15 December 2021

Our Ref: R/2021/4/A  
File No: 2021/518032  
Your Ref: SSI-19238057

### **Sydney Metro West - The Bays to Sydney CBD - SSI-19238057 - Advice on Environmental Impact Statement**

Figure 14-4 Predicted groundwater drawdown levels two years after the start of construction – Pymont Station construction sites

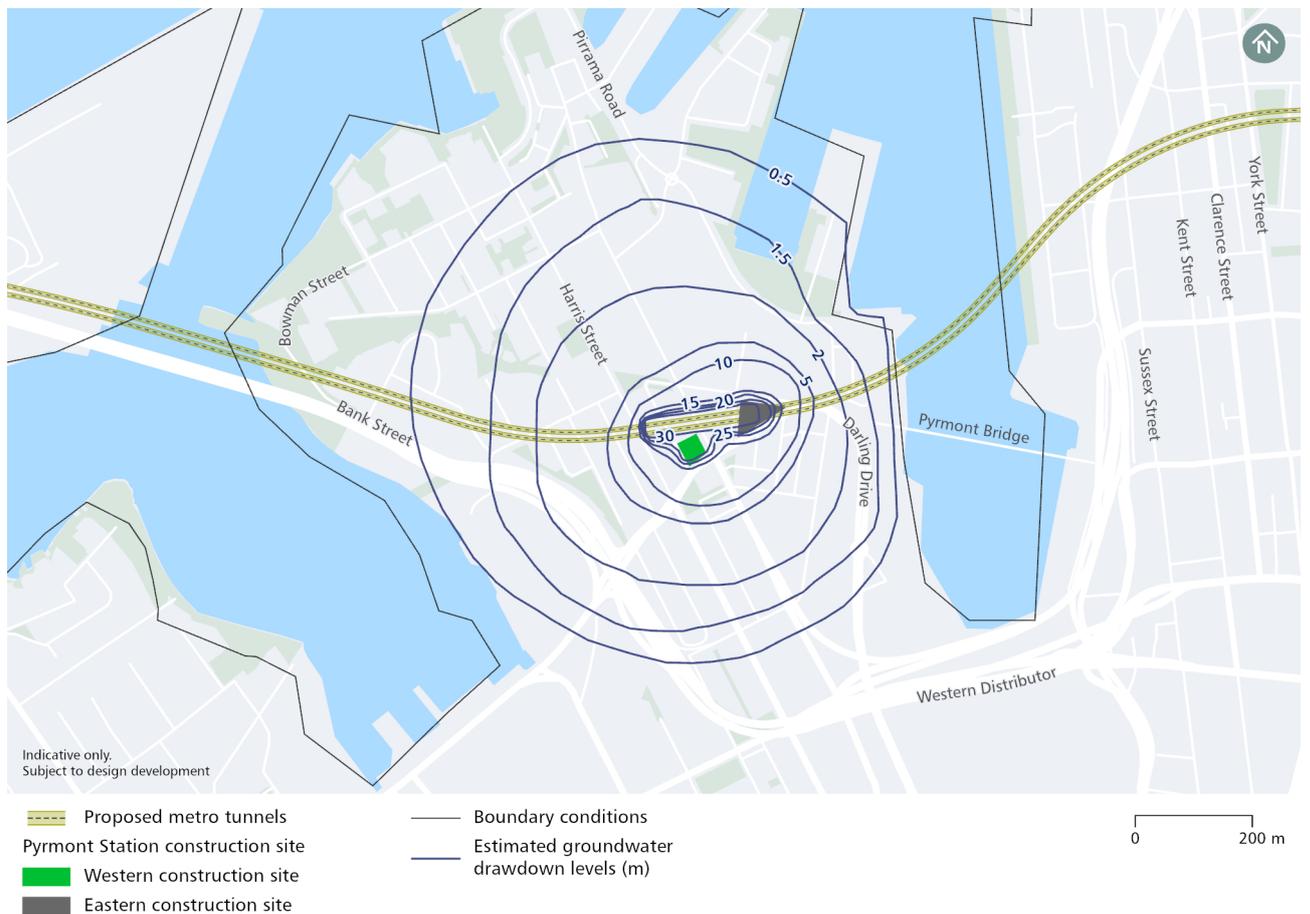
- The proposed excavations may cause groundwater inflows to the excavations, and associated groundwater level drawdown of groundwater, and potential for migration from source sites towards the construction site and management of dewatering during construction.

- The acid sulphate soils (Class 1 and Class 2) could be present around Pymont Station but are unlikely to occur around Hunter Station. There is potential for the oxidation of acid sulphate soils and potentially impact groundwater quality, groundwater dependent ecosystems, groundwater users and surface water-groundwater interactions. Further detailed investigations and an Acid Sulfate Management Plan is required for the Pymont Station location.
